Variance No. MIV-85-15

APPLICATION FOR VARIANCE

MEMORANDUM

SUBJECT: McGill Short Plat (proposed)

# PROPOSED SHORT PLAT

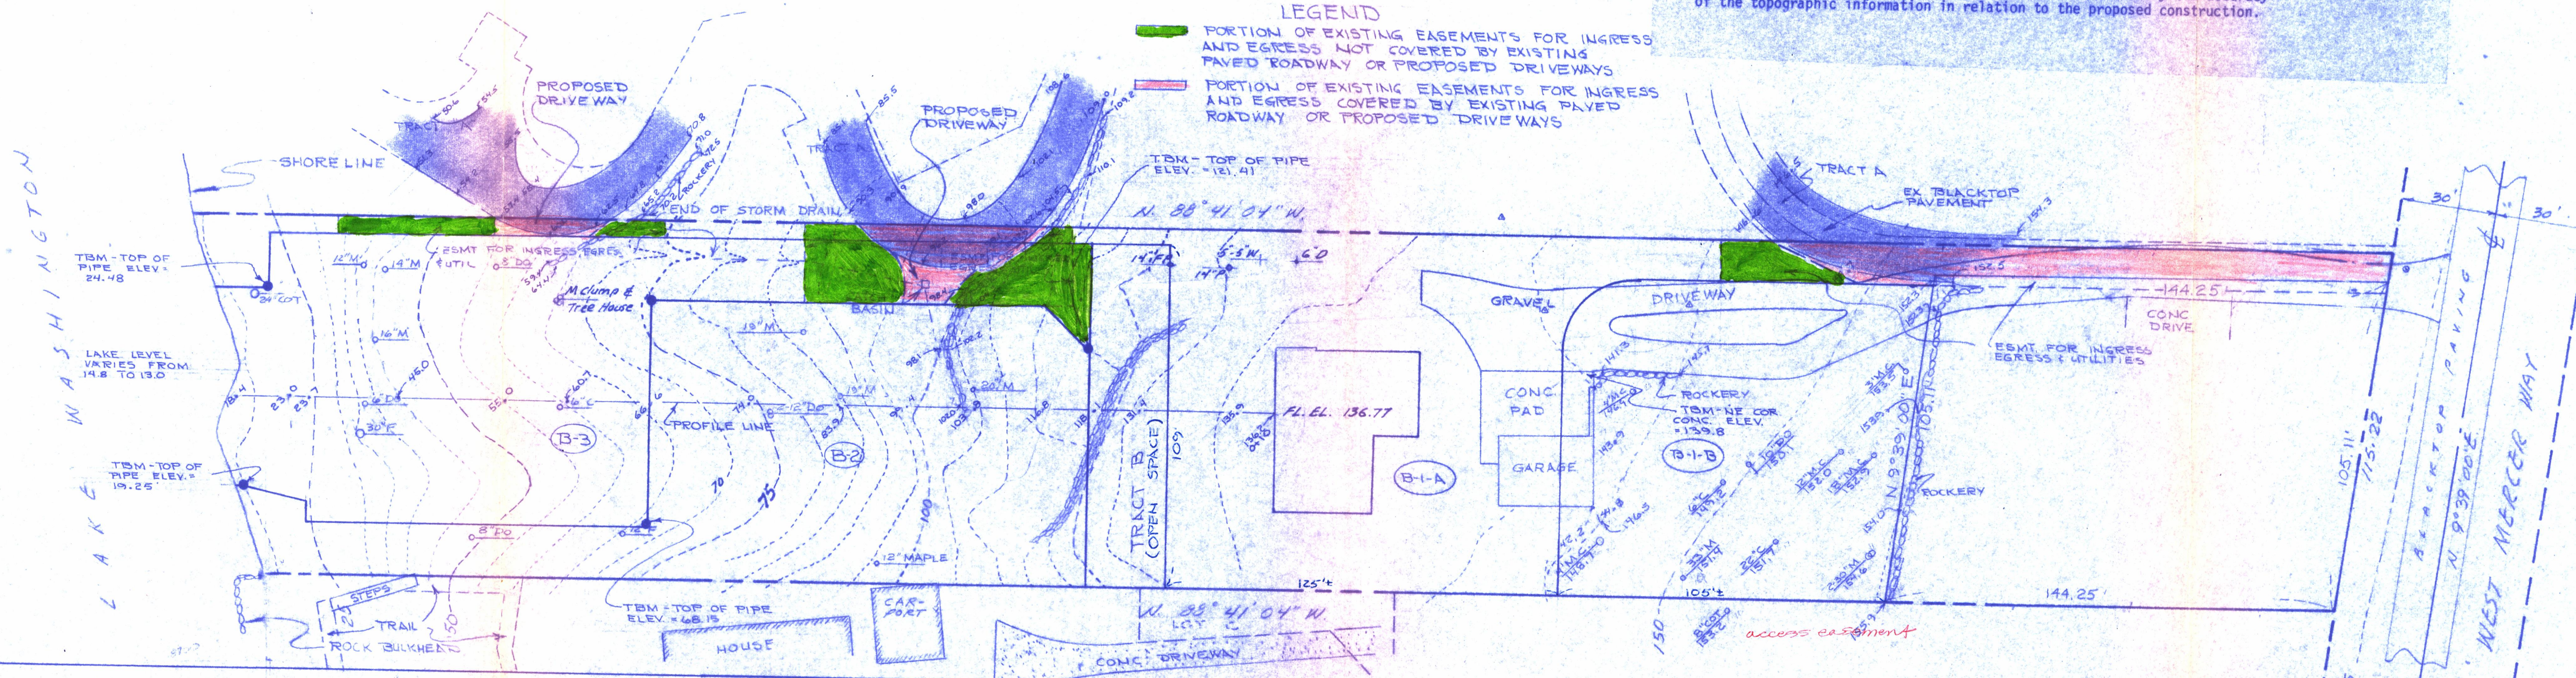
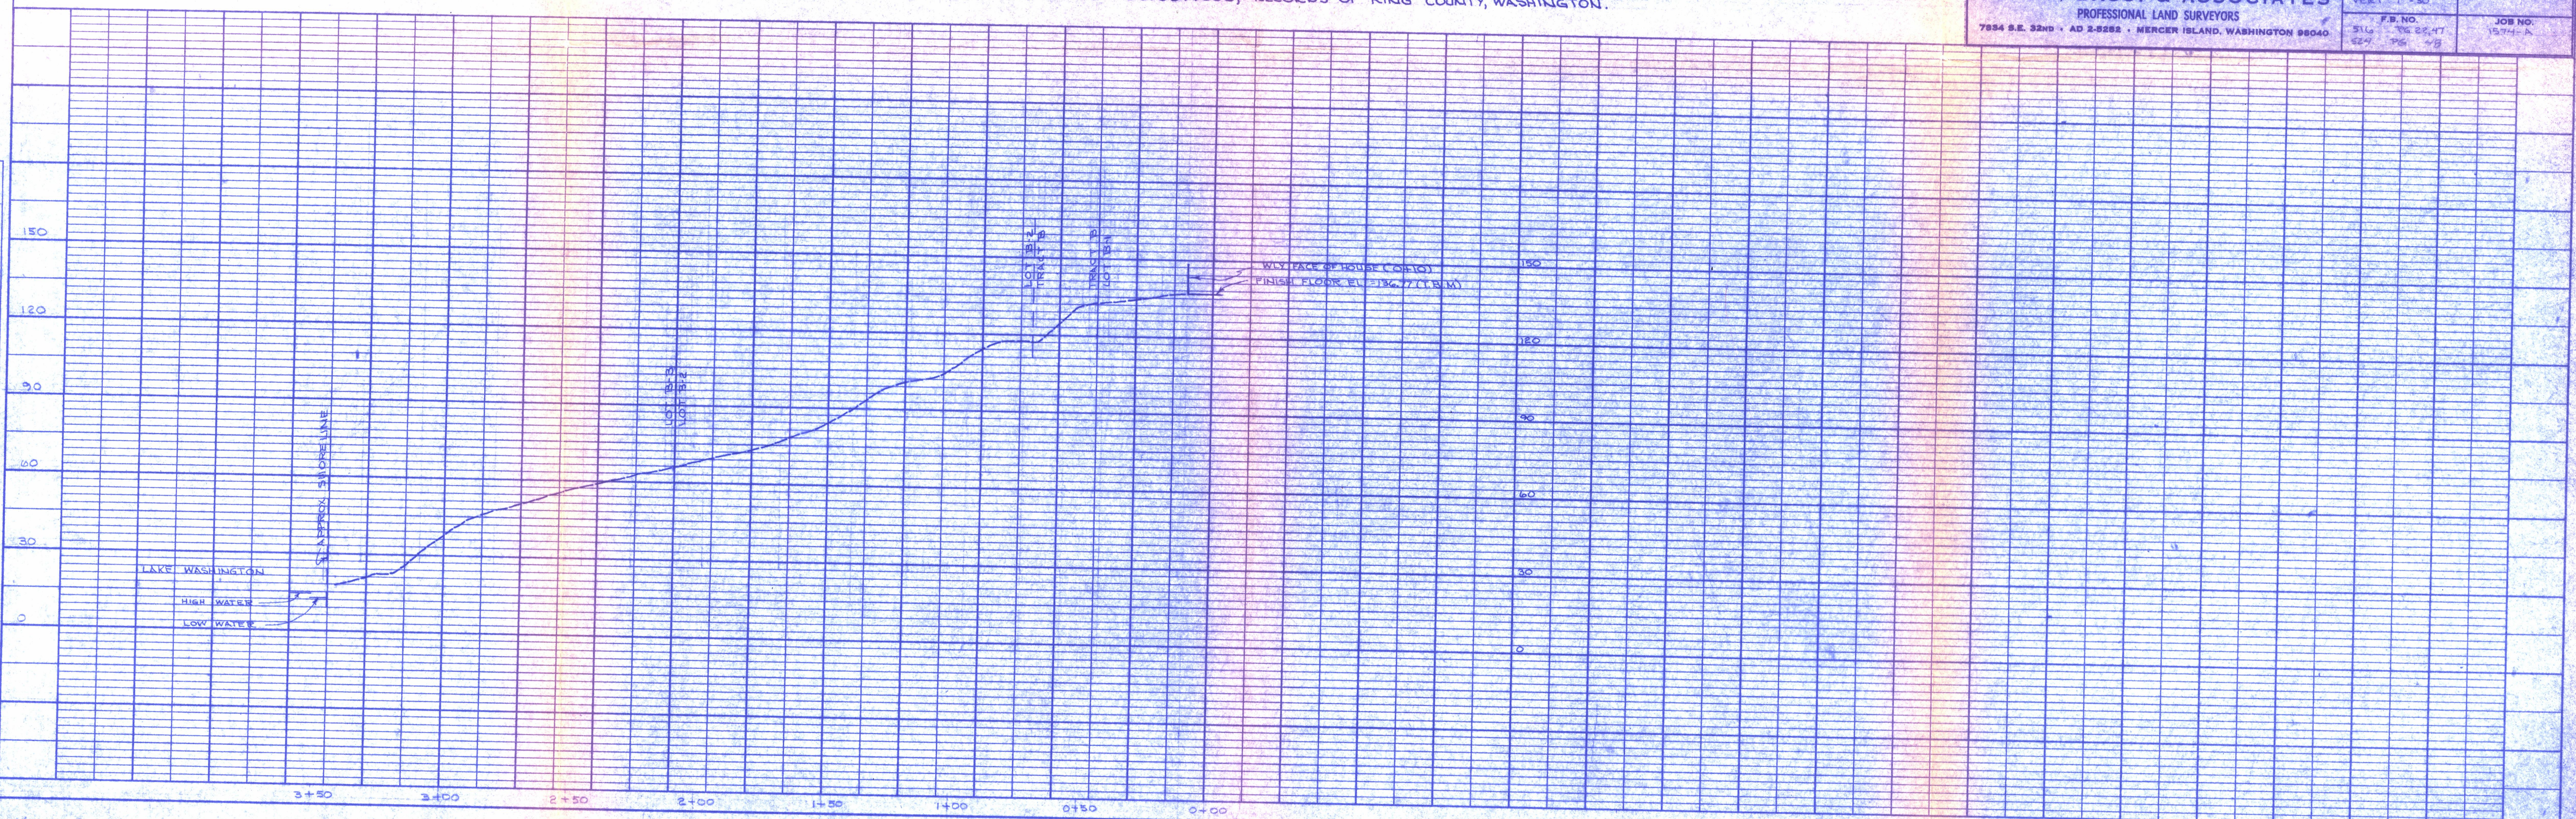
I do not have a problem with the release of the green marked easements for ingress and egress on Bob Jones's 1/9/85 drawing providing the easement under AF # 7903130959 is satisfied. The easement was recorded on the Villa Marbella Plat to the north and the release of this easement may require release from all property owners on that Plat and the property owners of the previous McGill Short Plat.

Please ask Bob Jones to research this issue and provide us with a copy of the AF # 7903130959 when he submits the proposed new McGill short plat.

The proposed short Plat should have utility easements that reflect as built utility locations. The N 10' strip may not be sufficient.
